DRB Project Number: 1004404
Valle Prado Unit 1

SUBJECT: Sketch Plat

D.R.B. Case No: 1004404	Date: 07/29/15	Item No: #10
Zone Atlas Page: C - 9	LOCATION: Lots 29 & 30, Valle Prado Unit 1 and Tract E, The Trails Woodmont and Rainbow	
Request For: 15DRB-70255 Sketch Plat

Skch Plat
Unit 1
Lots 29 and 30

SKETCH PLAN

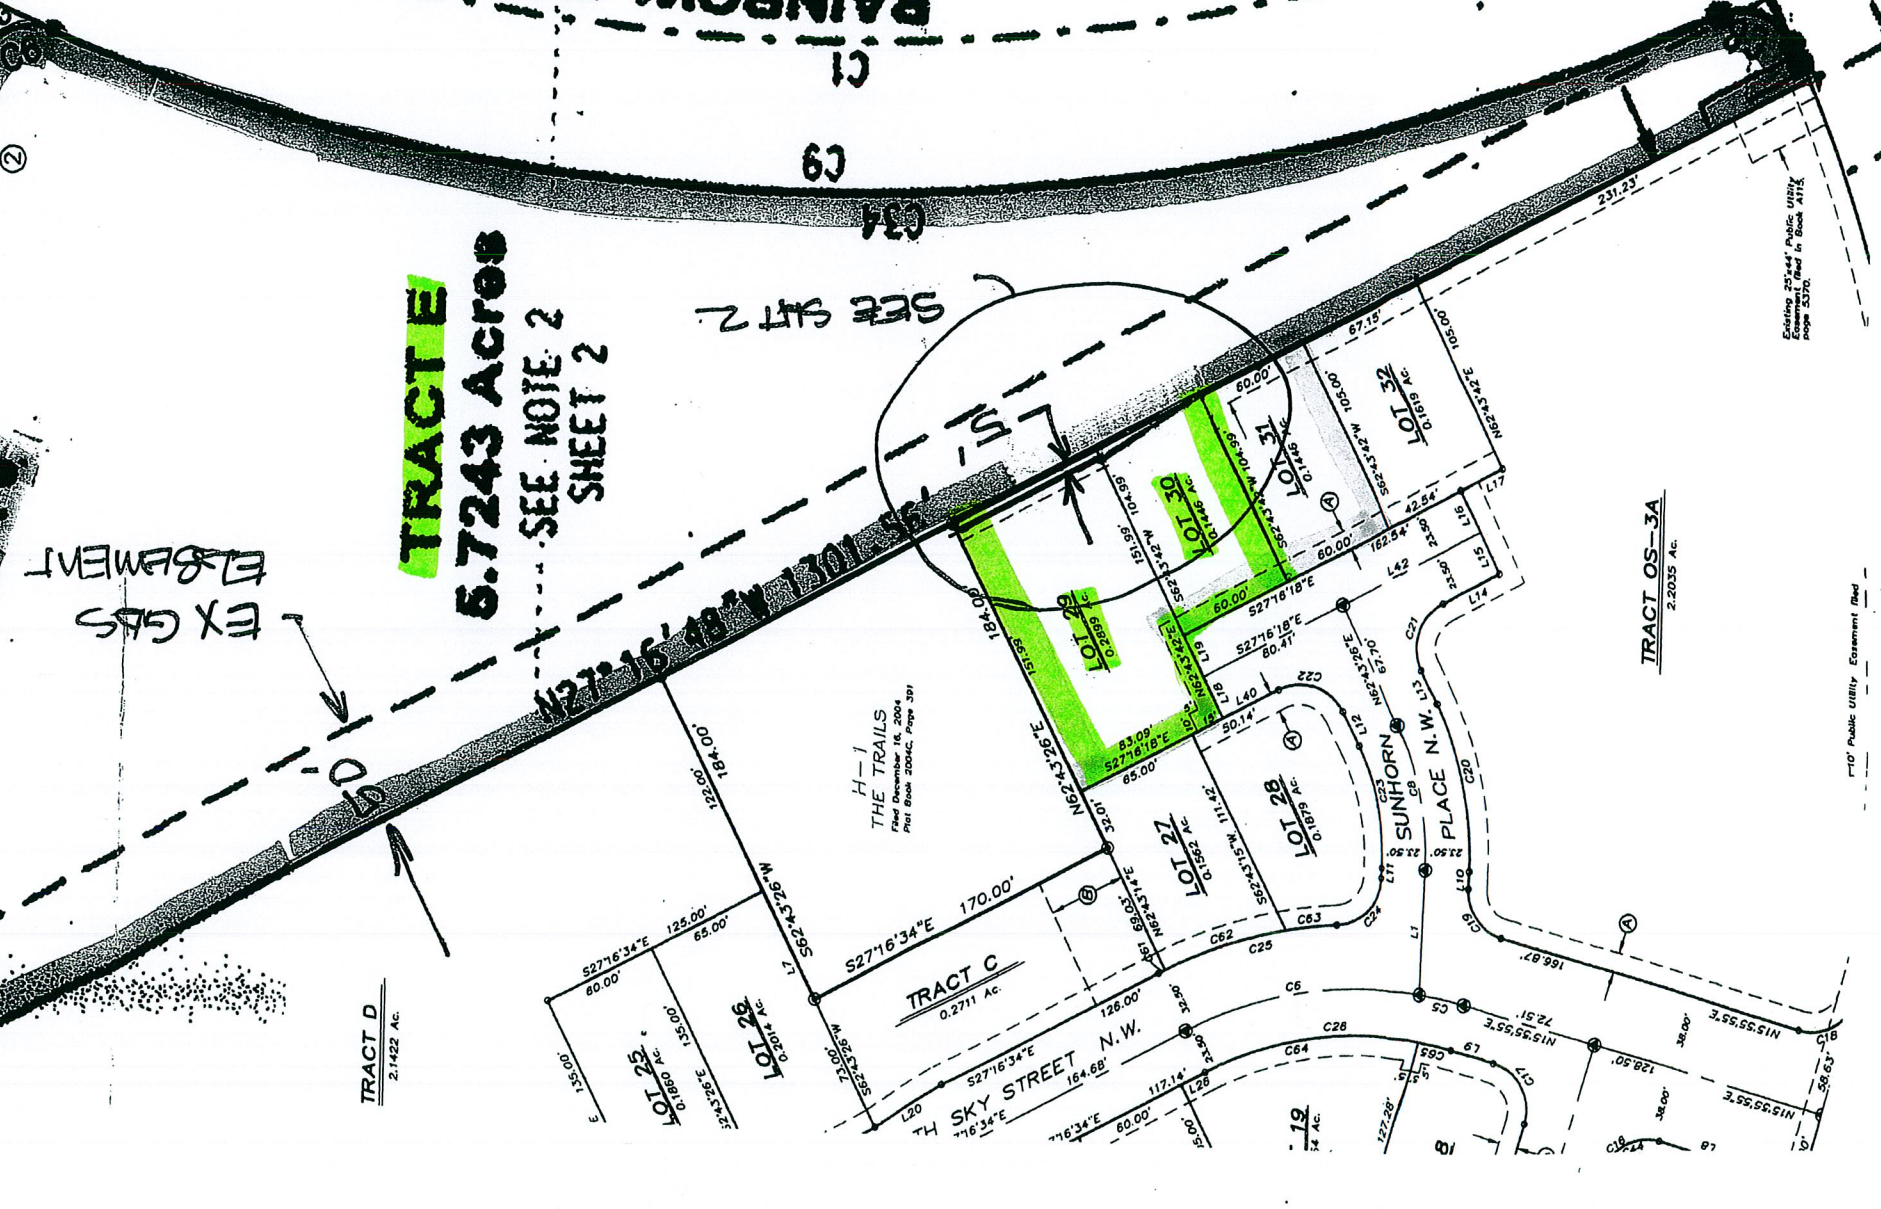
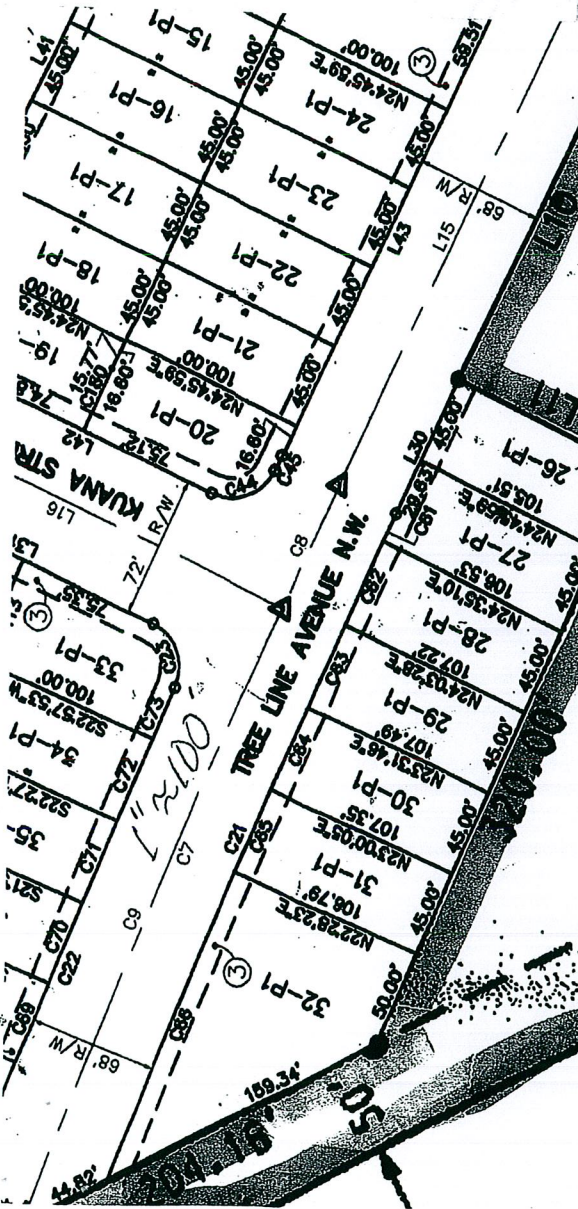
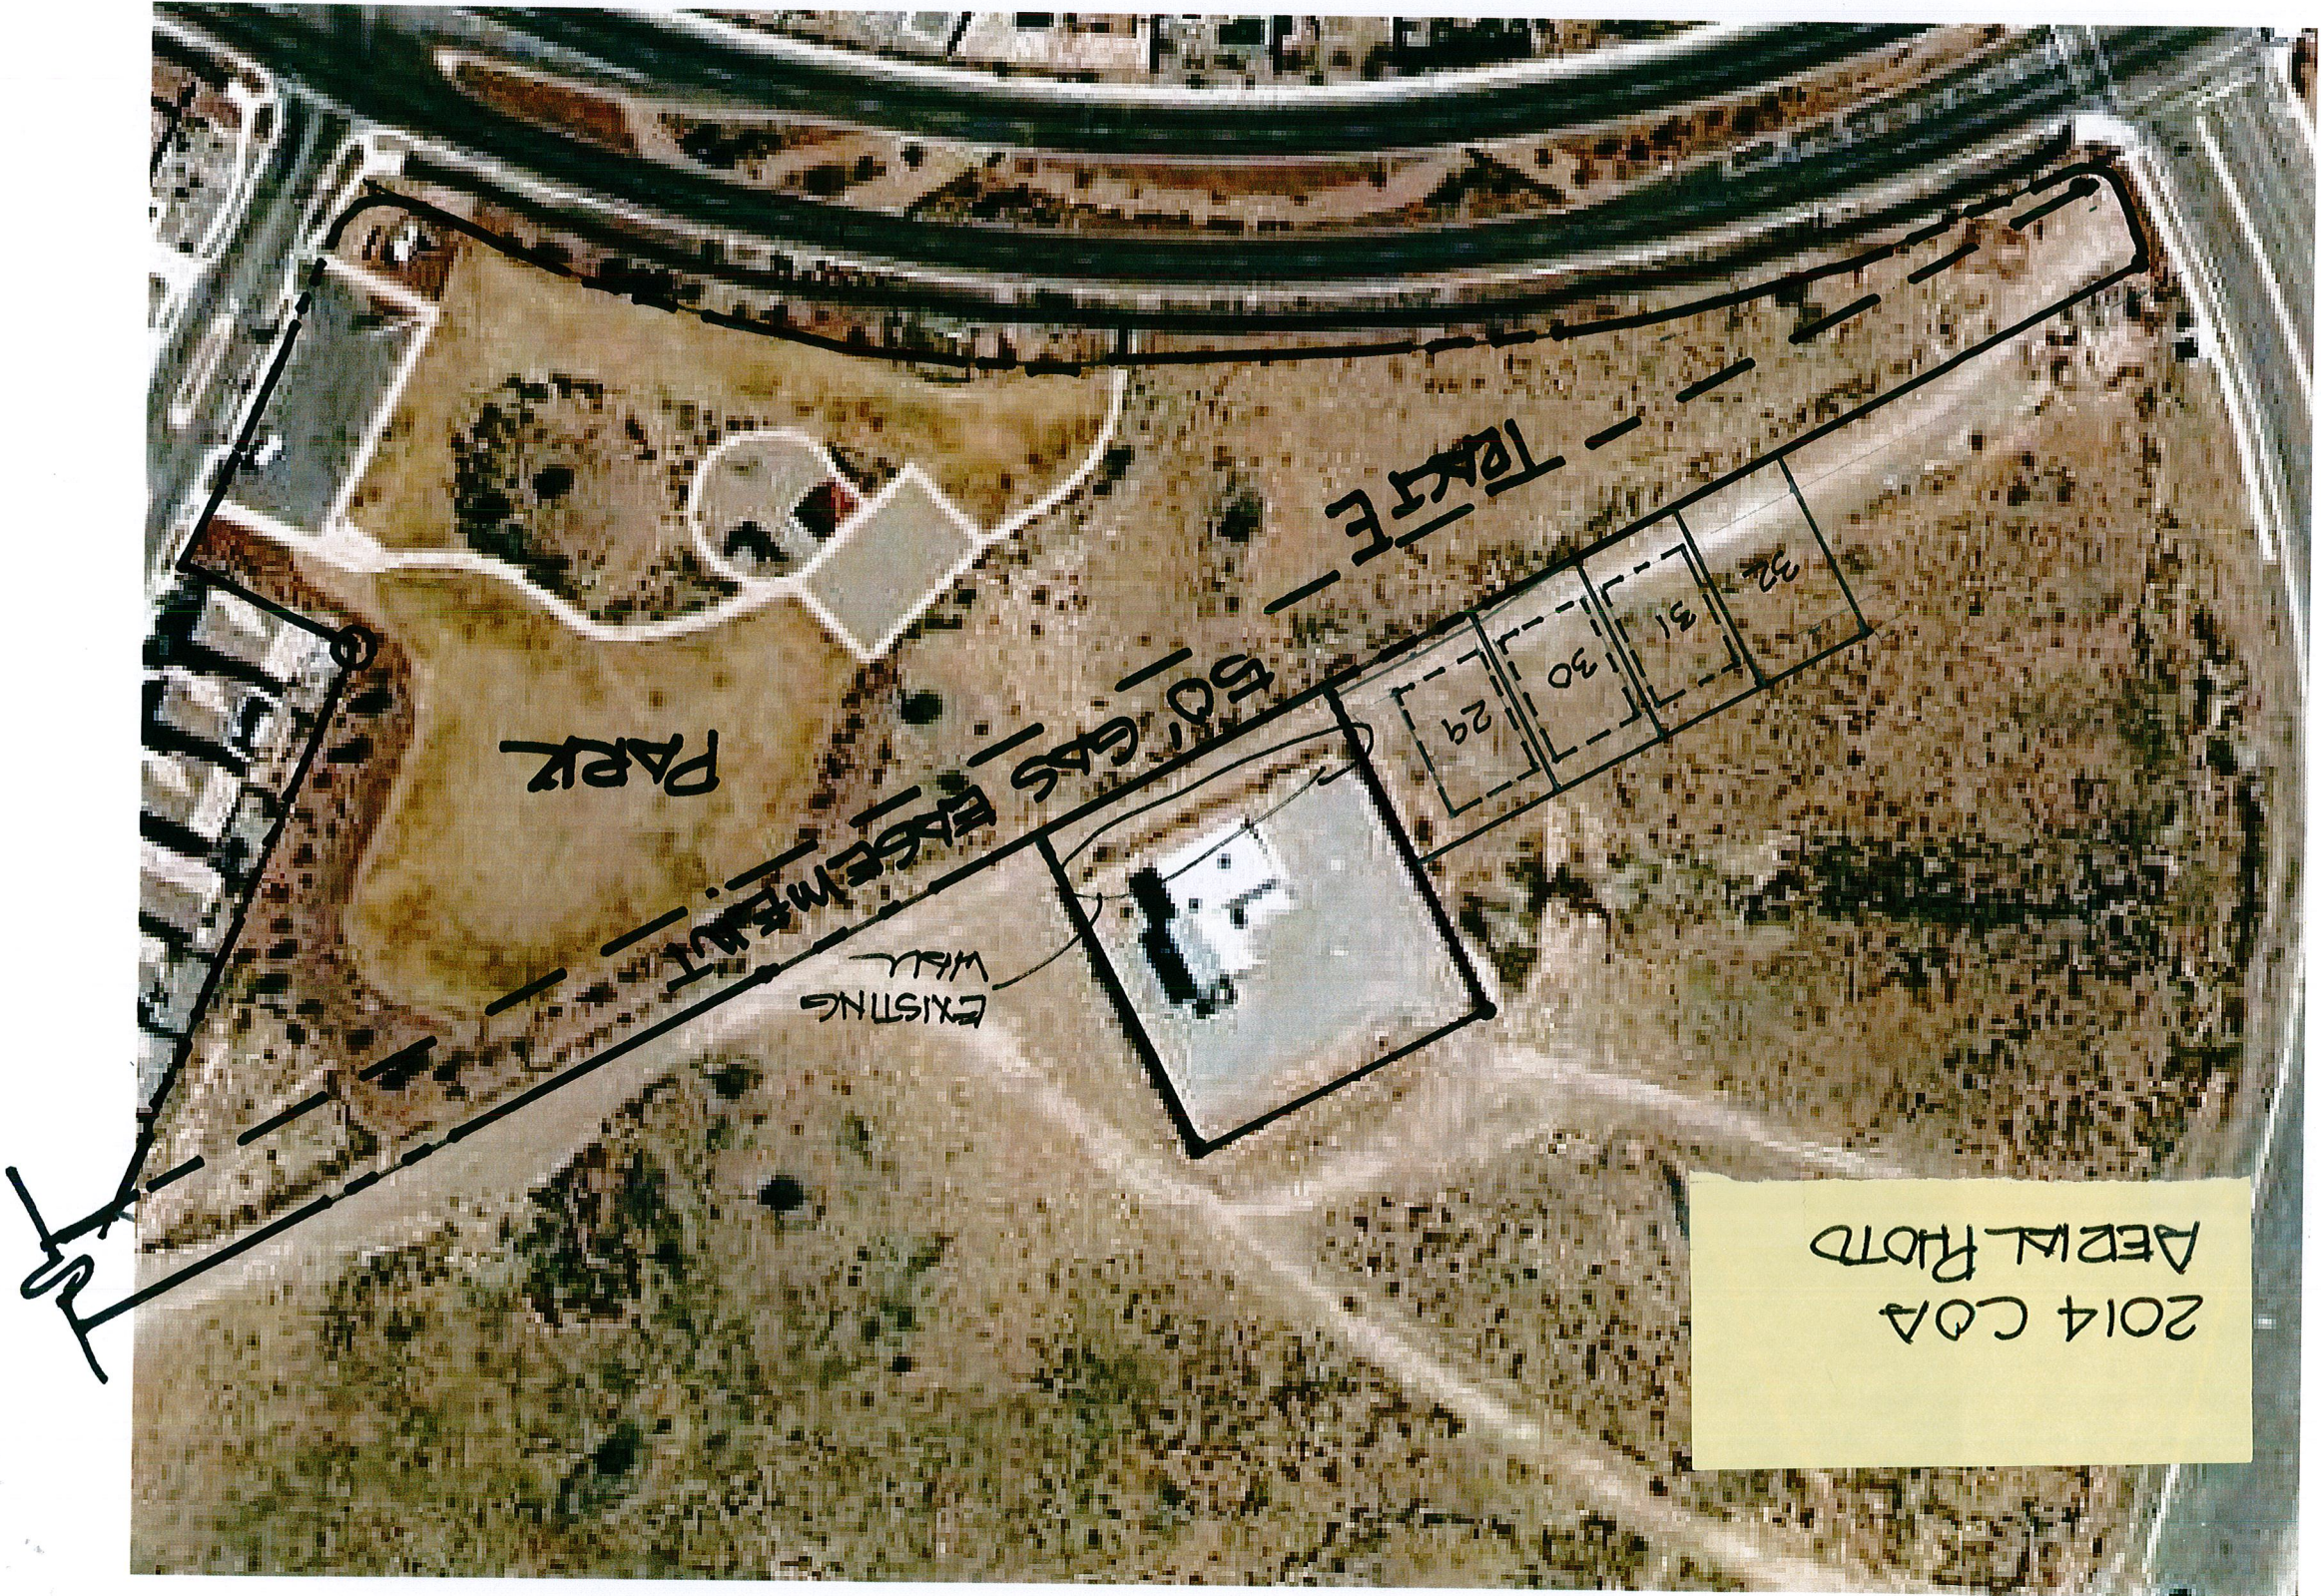
8 1/2 x 11 only
↙ Revise the Grading Plan for these lots. A retaining wall may be needed at the NW corner of Lot 29.

The PUE will need to shift as well, leaving only a 5' distance between the PUE and the structure. Verify with utilities there is not a minimum distance required.
